# SPRINGS AT WATERVIEW PRELIMINARY PLAN

LOCATED IN THE NW 1/4 OF SECTION 7, T15S, R65W OF THE 6TH P.M.,  
EL PASO COUNTY, STATE OF COLORADO

PROJECT SPRINGS AT WATERVIEW

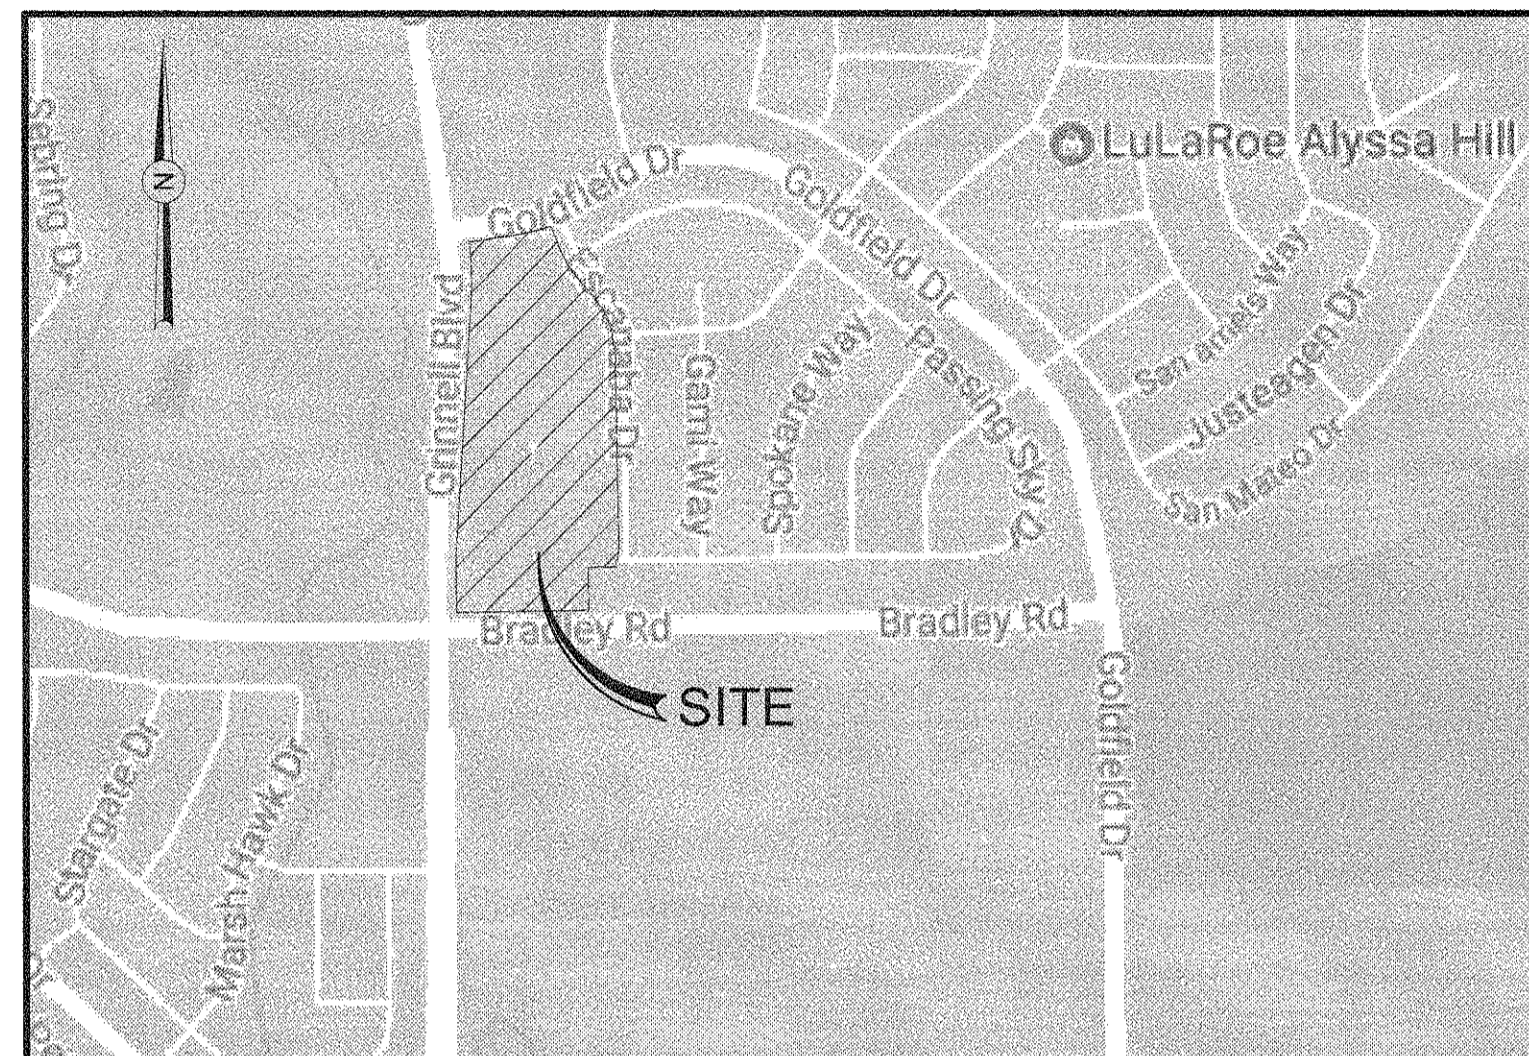
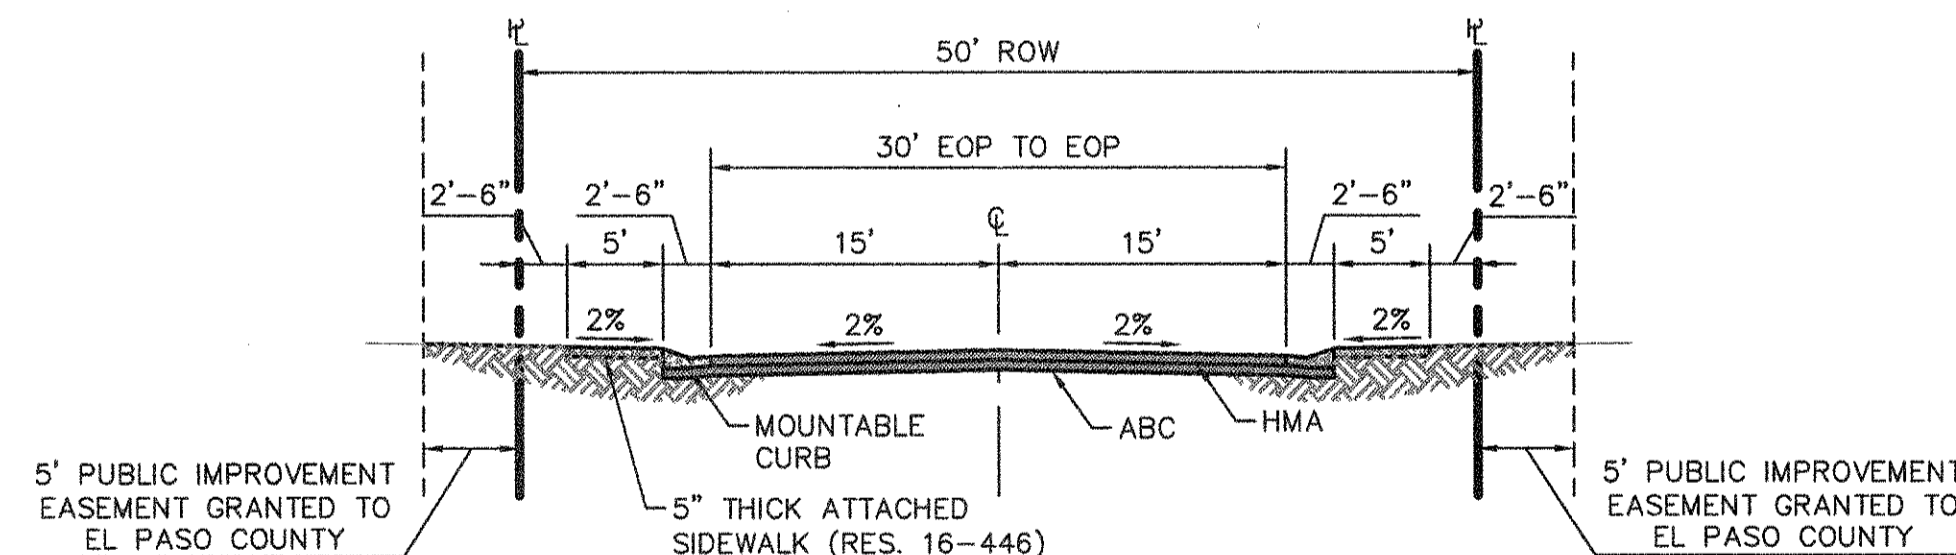
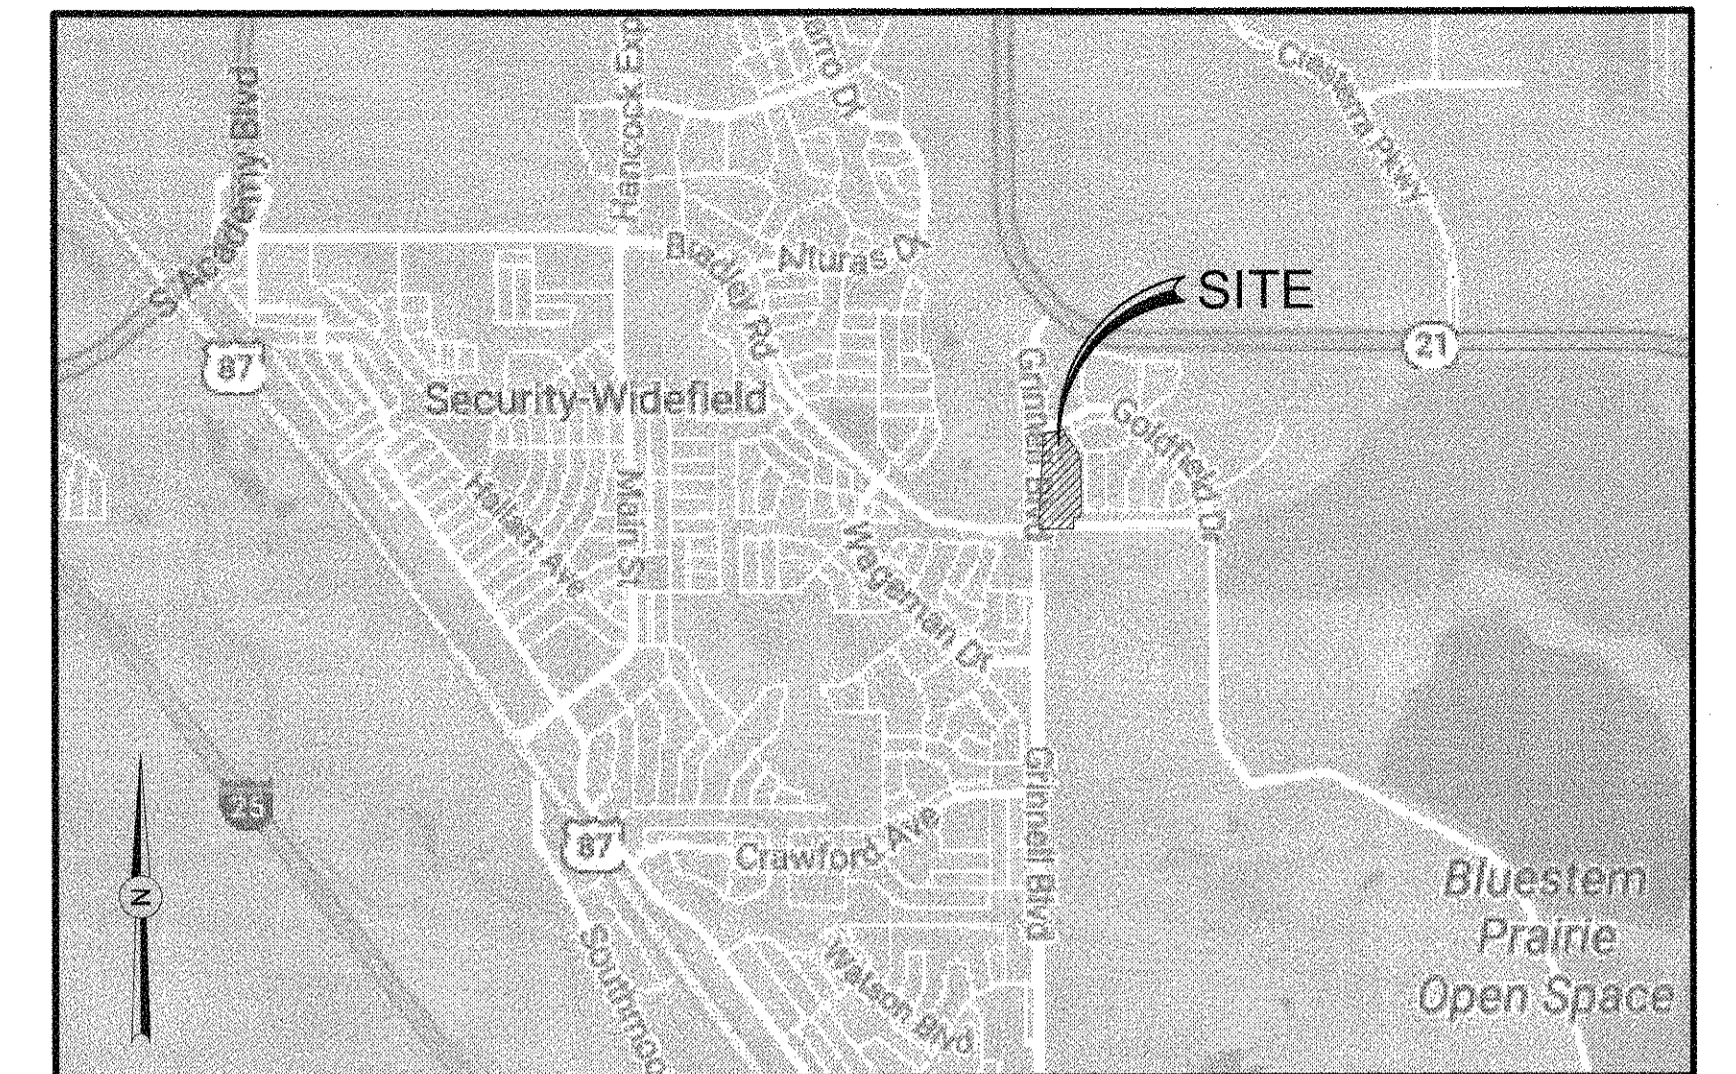
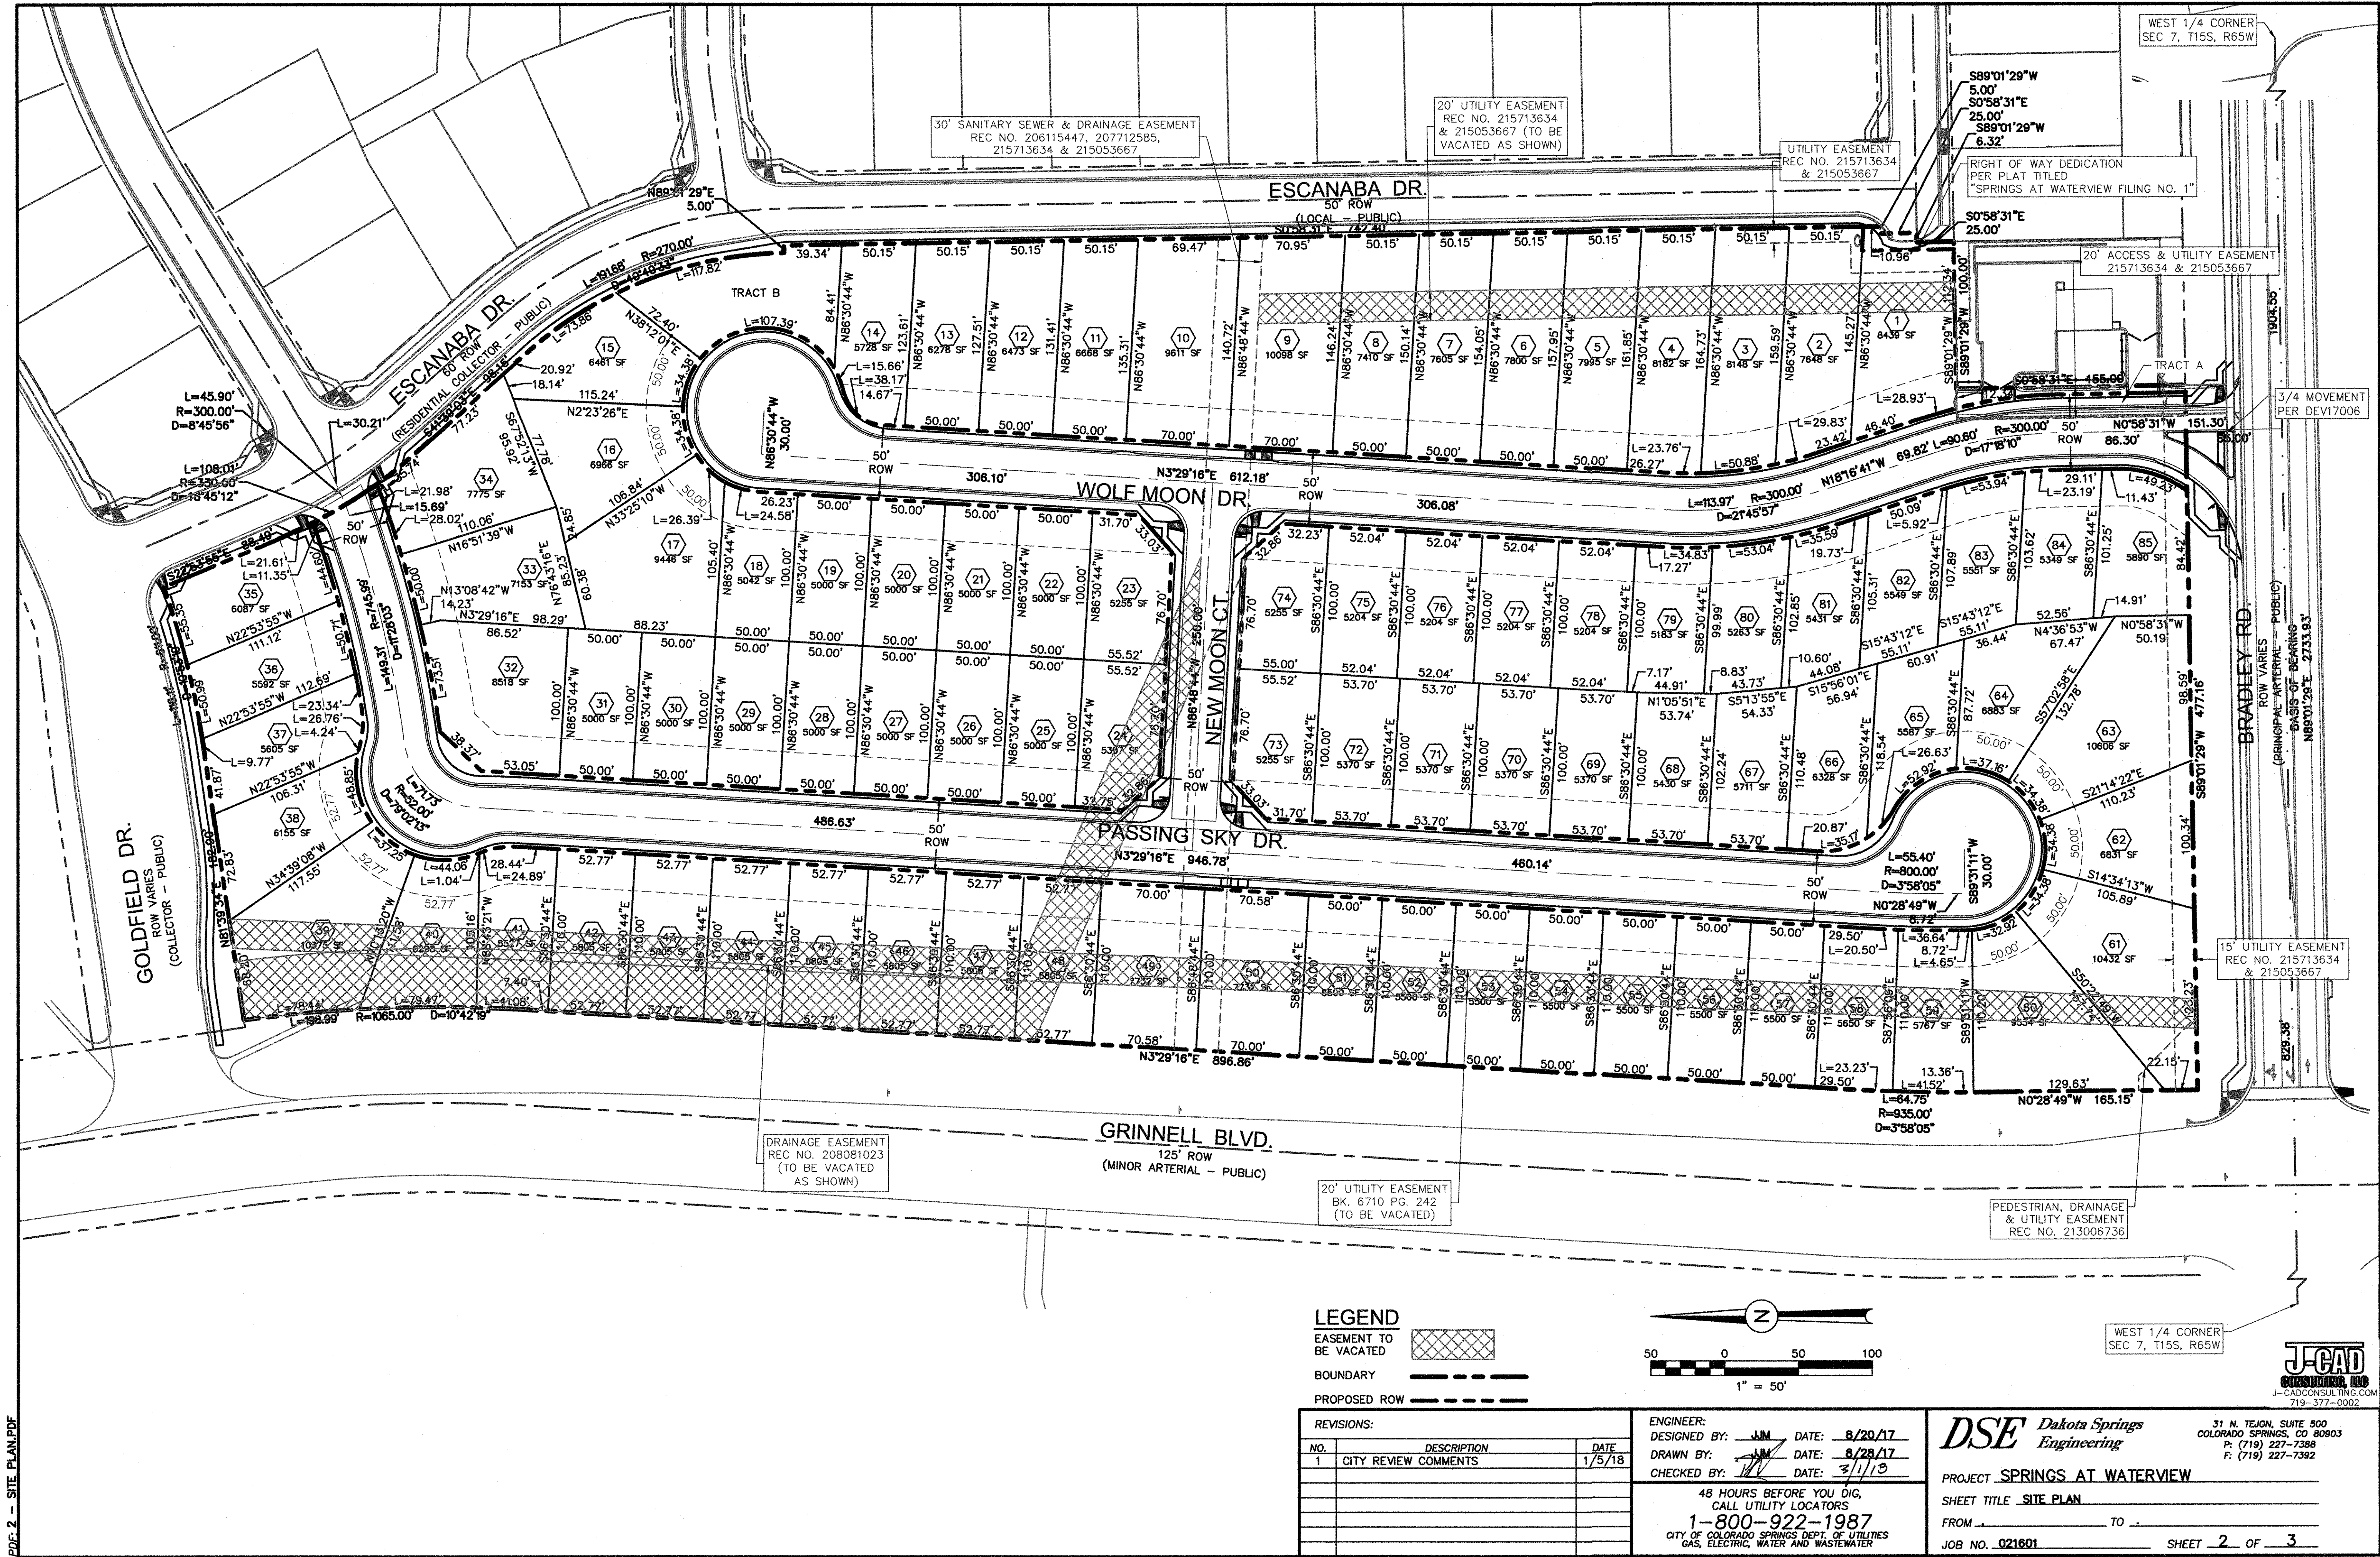
Provide the specific FEMA FIRM Panel No. Unresolved.

*This seems out of place*

*Lower outcounry water table*

Identify the classification. Unresolved.

*ADDED PANEL NO. TO NOTE*

*ADDED GRINNELL BLVD*

*CORRECTED*
